WEST SUSSEX COUNTY COUNCIL CONSULTATION

TO:	Arun District Council FAO: Kathryn Welch
FROM:	WSCC - Highways Authority
DATE:	13 September 2021
LOCATION:	8 Beagle Drive Ford BN18 0NY
SUBJECT:	F/11/21/PL Installation of a prefabricated concrete workshop at rear of properties garden with rear access onto Lewis Lane and retrospective application for the historical realignment of the rear boundary fence. This application is in CIL Zone 2 (zero rated) as other development.
DATE OF SITE VISIT:	n/a
RECOMMENDATION:	Advice / Modification
S106 CONTRIBUTION TOTAL:	n/a

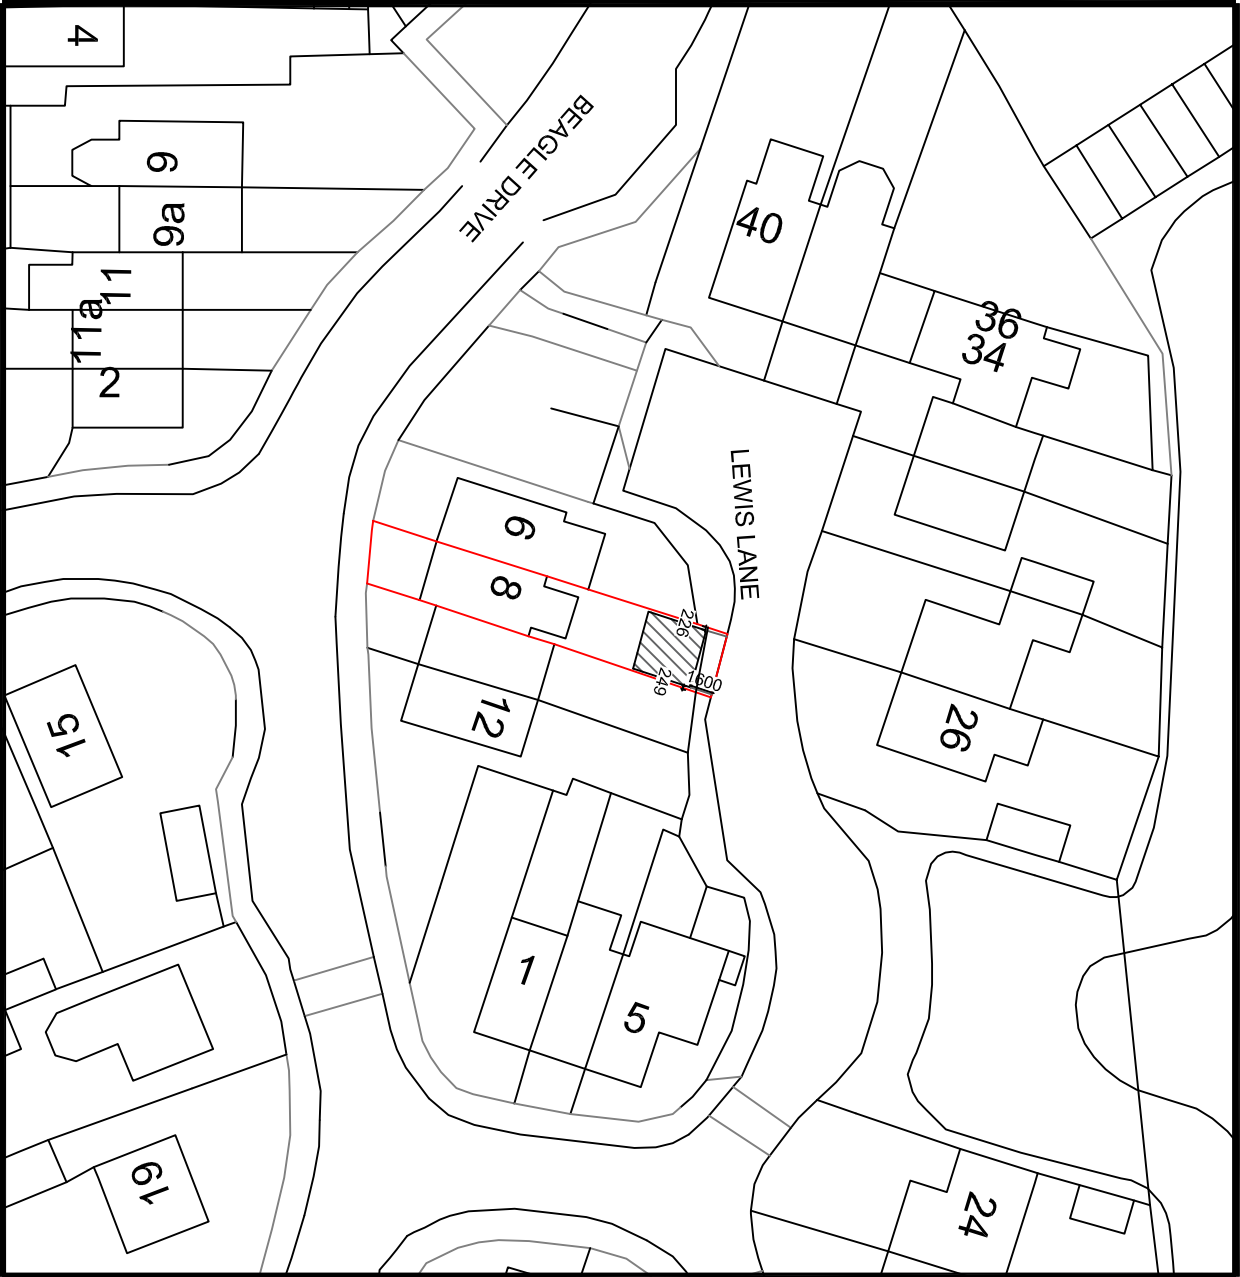
The LHA has been re-consulted on this application following request for more information pertaining to the hard-standing to the rear of the site, and the realignment of the rear boundary fence.

The applicant has confirmed that the rear boundary line has not been altered and is not proposed to be altered. On the basis that the LPA are satisfied that the boundary has not been re-sited, the LHA would not make further comments.

The applicant has confirmed to the LPA that the hard-standing to the rear of the site does not currently provide a dropped kerb. The applicant has confirmed that the building will be provided with a formalised dropped kerb, constructed under licence to WSCC specifications. The LHA would not raise any highway safety concerns to the proposal to formalise the access in this location; however I have consulted the Area Engineer regarding this proposal and he has confirmed that they would not grant a licence for the dropped kerb due to the property having an existing vehicular access to the west of the site which provides parking provision for vehicles.

The applicant has confirmed that the building was originally constructed to be utilised by a motorcycle, which has now been sold, and is currently used for cycle and bin storage. The building scales off to approximately 3.9 x 4m which is not considered to be sufficient size for a vehicle to park.

Given all the matters raised above, it is recommended that the applicant modify the proposal to remove the proposed hard-standing and not provide a vehicular access to the outbuilding. This would require that the existing unlawful hard-standing be removed and the verge re-instated to grass.
